Re: Town & Country Planning Act 1990

Application ref: P/~~47/11~~ - 52 East Front Road Pagham

Proposed new extensions 52 East Front Road Pagham

For	Date	Dwg by	Revision
Mr and Mrs Evers	24.05.2011	sk	C
Title	Scale	Project no	Dwg no
PROPOSED LAYOUT, ELEVATIONS AND SECTION A-A	1:50	126	P2

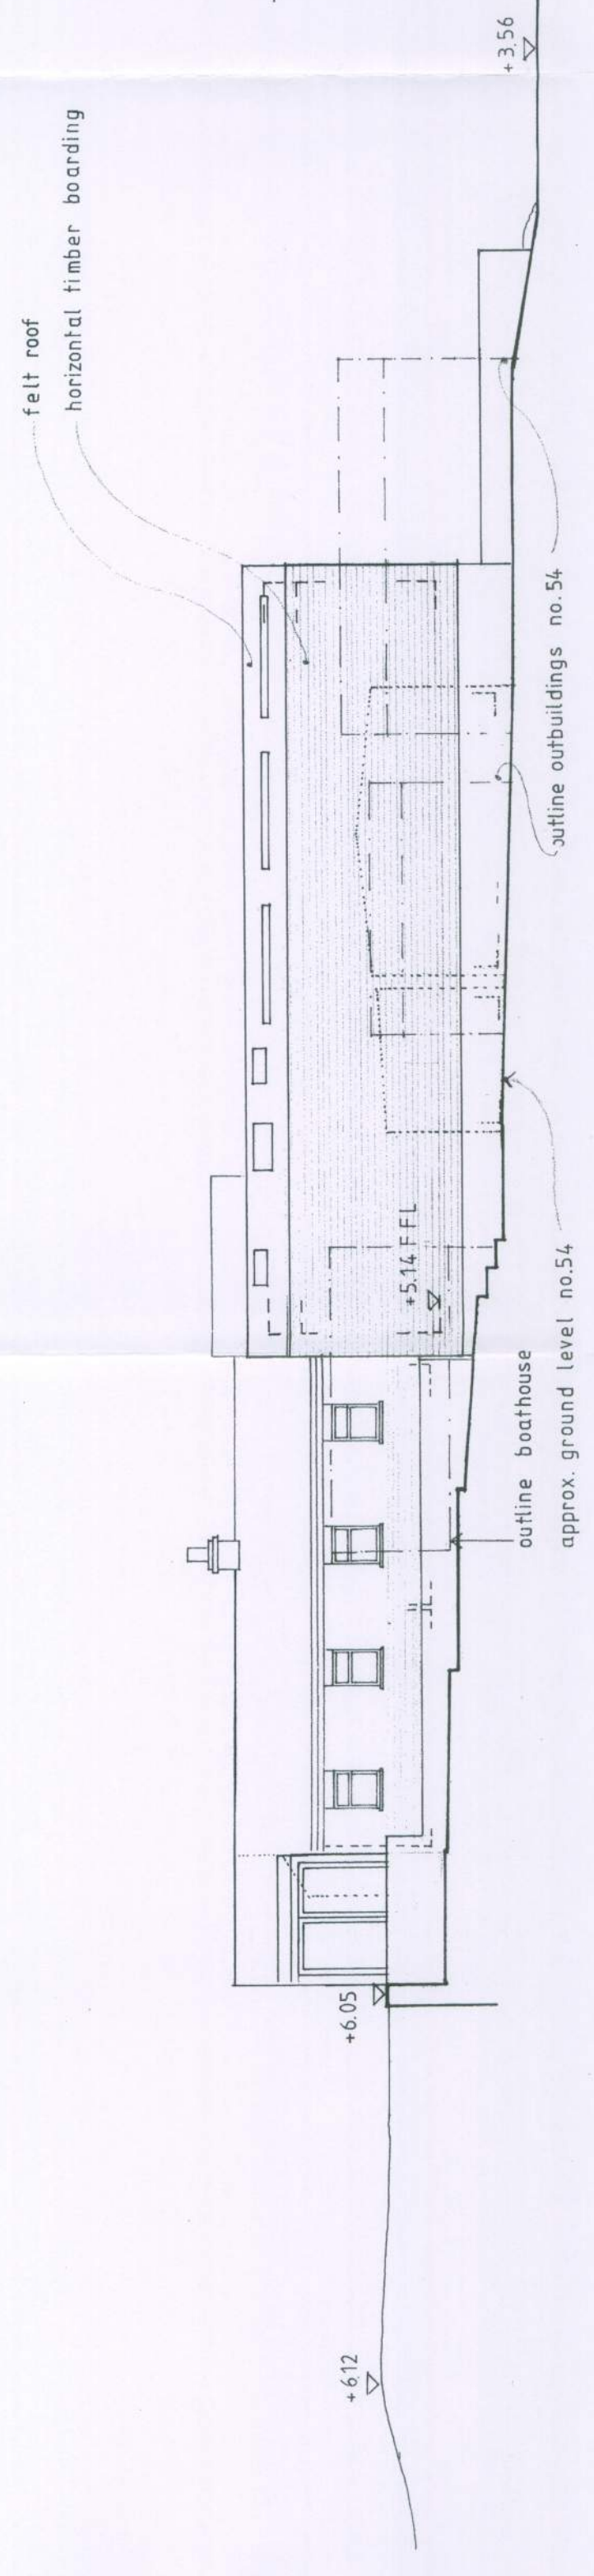
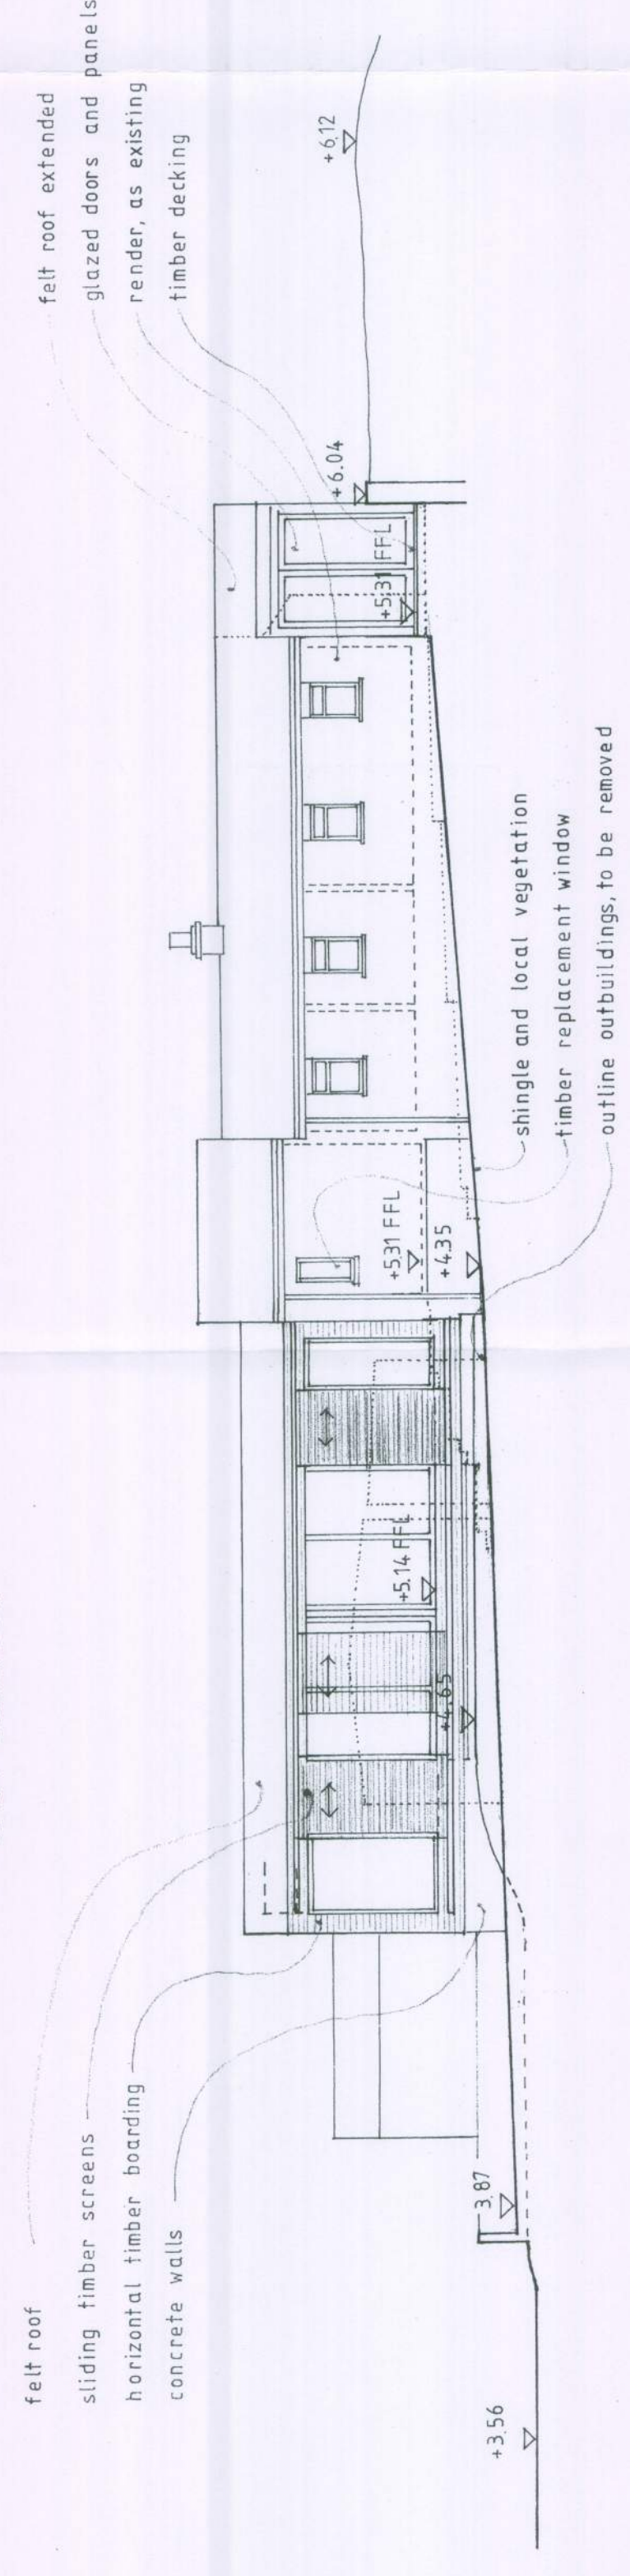
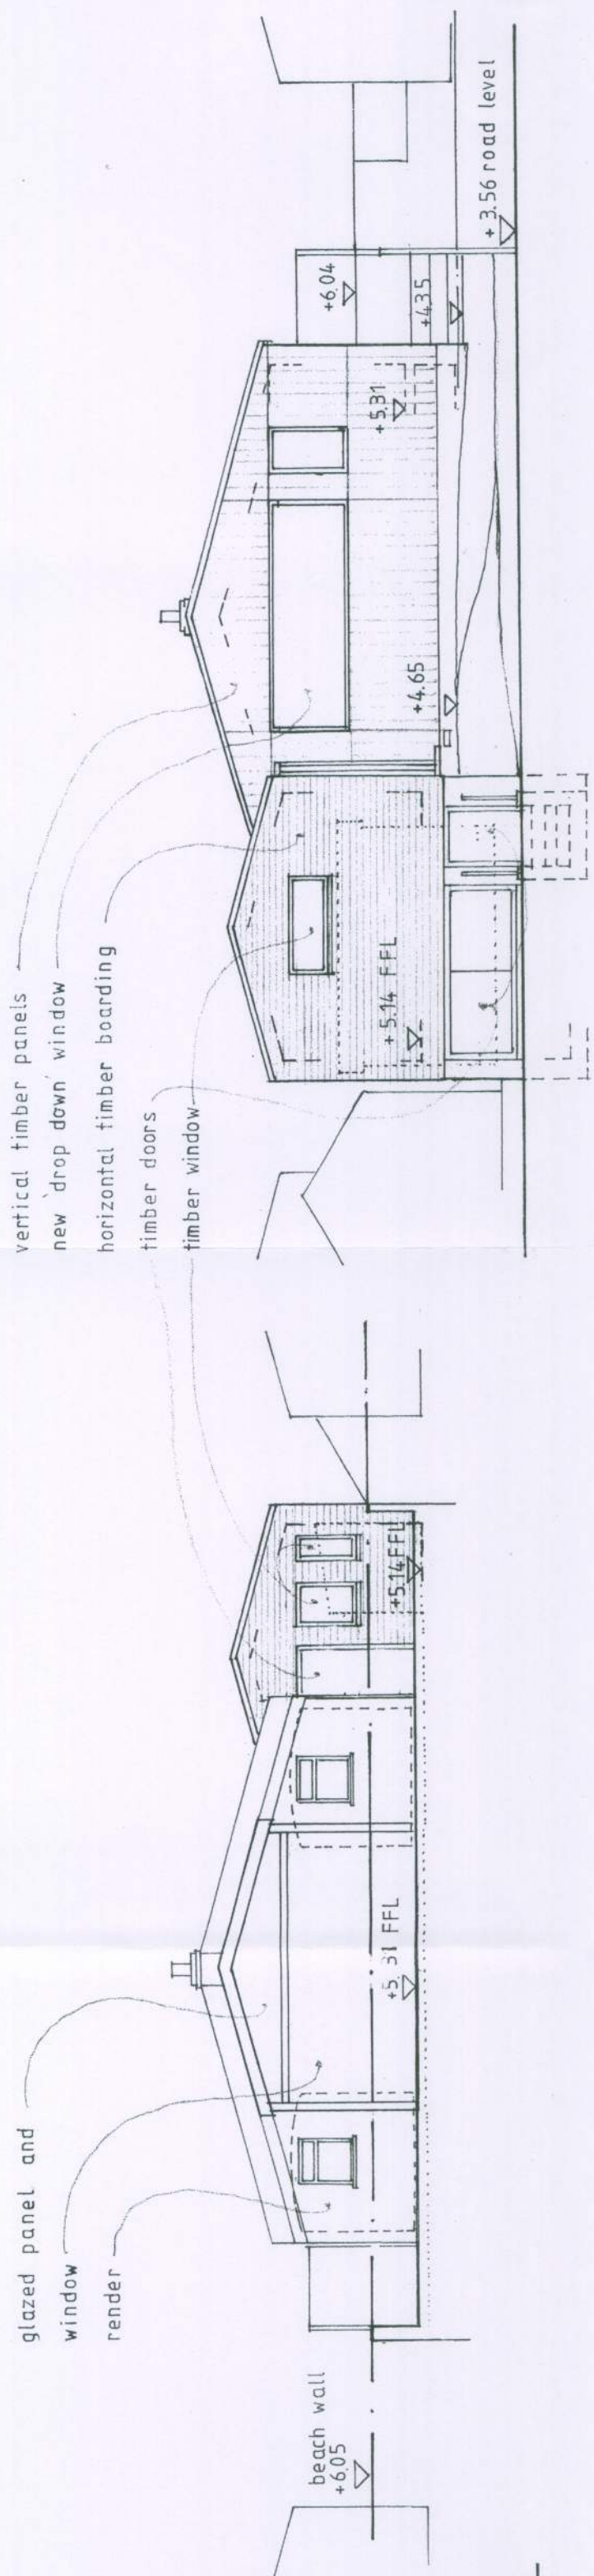
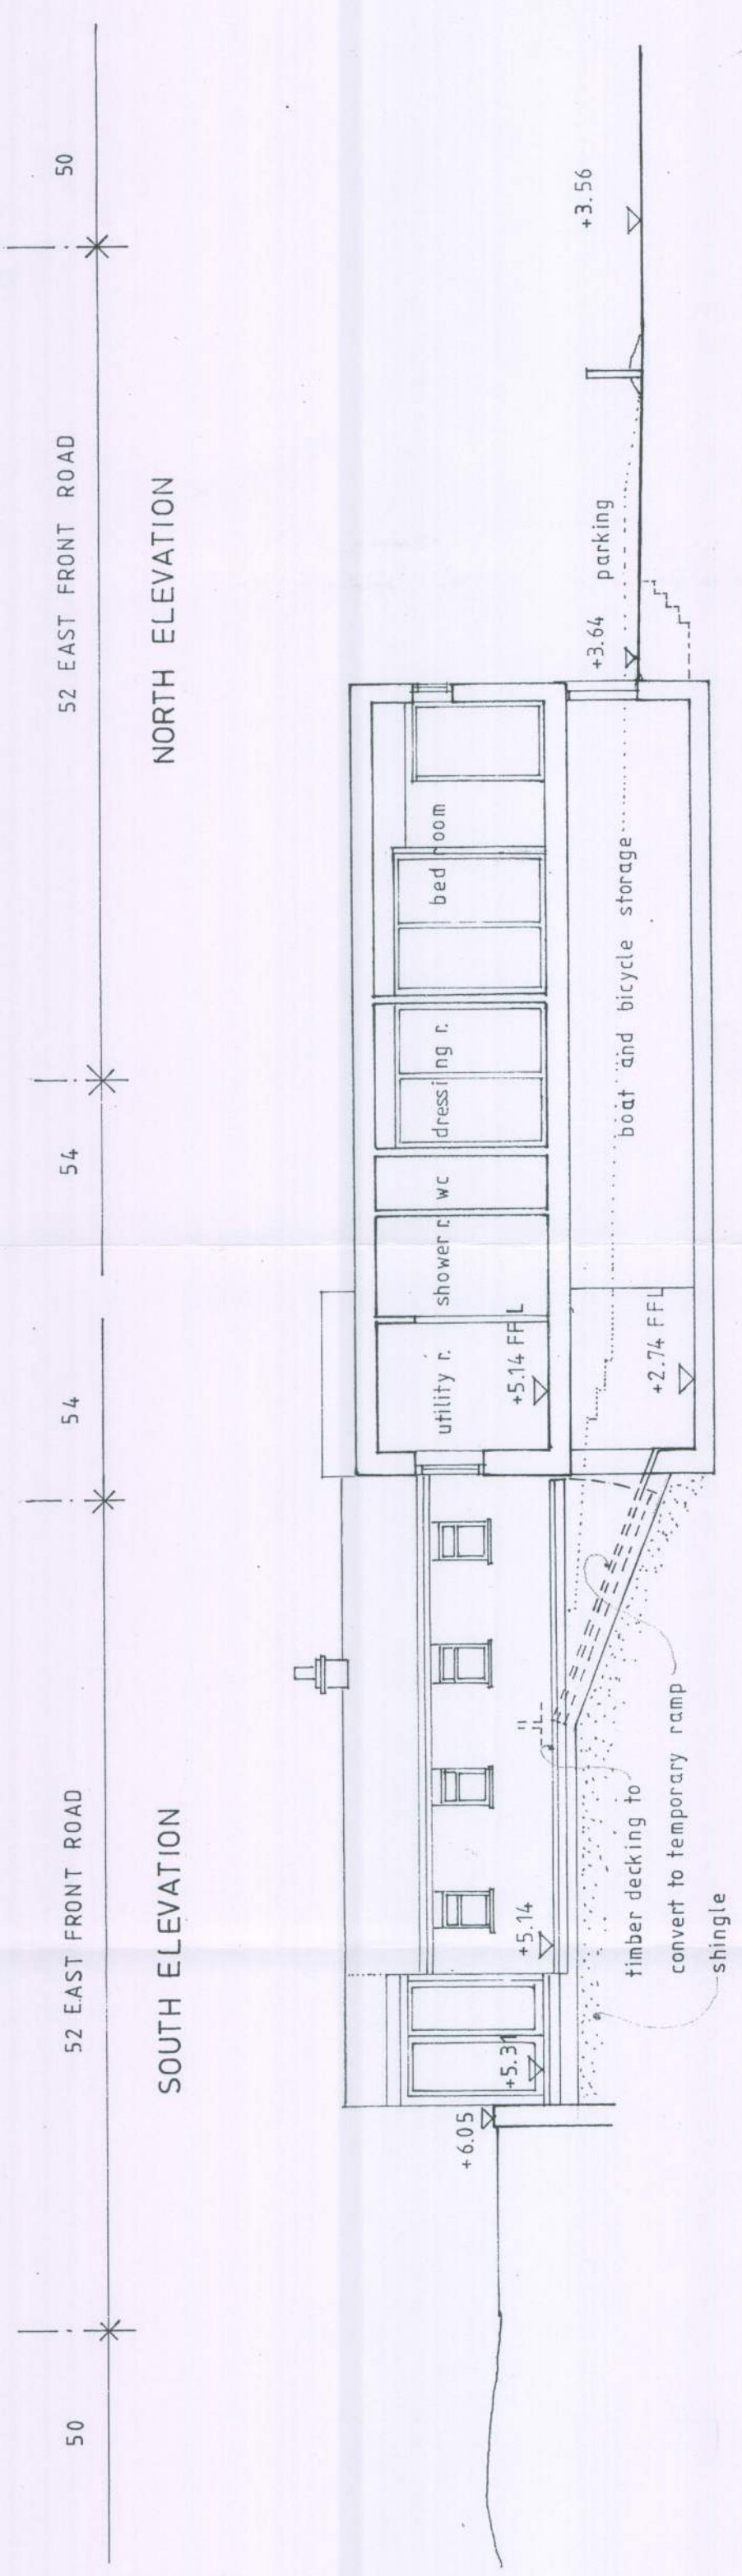
- ii) The proposed construction (no construction details are available to us) has been mooted as timber frame and timber clad. The issue of Fire hazard is therefore of great concern - especially if the Fire break is reduced to 1660mm. Please remember that the prevailing Westerly/North Westerly puts us 1st in line if the proposed extension catches fire. We will be just 1.6 metres to the East which is unacceptable to us- the breezes here on the beach are much stronger than elsewhere locally and the area of SSSI land just the other side of East Front Road is often set fire by visiting children from the caravan park at Church Farm during summer months.

Also, the existing roof material of no.52 is mineral felt ,itself being potentially flammable from flying sparks and especially FIREWORKS and BARBECUES both of which the proposers are frequent participants in. Cladding in timber will require a fireproof paint finish to the exterior of the East flank of the building, which is going to be visually unacceptable to us. Furthermore, we are in the process of fencing the boundary in our own choice and style of timber and colour. The proposers will be therefore unable to service and maintain any paint finish applied to the East flank of their buildings (unless they are built away from the boundary.

We are deeply concerned about subsidence and landslip as the proposed construction is on the boundary just 1660mm from our building. The boundary wall removal is bound to damage our path and our main building is only supported on brick piers on shingle. It is highly likely there will be collateral damage of some sort. From the plans it appears the depth of excavation would need to be in excess of 3 metres in order to facilitate the footings of the below- ground room that is proposed underneath the accommodation floor.

- v) The bulk of the proposal right on the boundary effectively eliminates our view to the west with its trees and hedgerow down to Pagham parade and all the SSSI to the west of us . We will be staring at a blank wall towering above our own fence and obscuring a large part of the evening sunshine which we have enjoyed for the last 27 years since buying our bungalow. The proposer assured us he would keep the height to an absolute minimum. We feel he has reneged on this assurance as he has on others. We are suspicious that the proposed design readily allows for another storey to be build atop of this present proposal using the "verandah" as the ideal site to place the staircase to the 2nd floor. The

- vii) Rainwater gutters and downpipes. None are shown on the plans but no overhang of our vertical boundary of any part of the building or finishes would be acceptable.
- viii) Part of the proposal involves a party wall. No approach has been made to us regarding the necessary handling of this legal matter. Until such legal matters have been notified we cannot agree to any activity which will impinge on our boundary. This project would fall under the Party Wall Act 1996.
- ix) Building to the boundary will effectively prevent us from maintenance to the west side window (now over boarded) and west wall of our garage. Although a small distance from the boundary was achieved - in
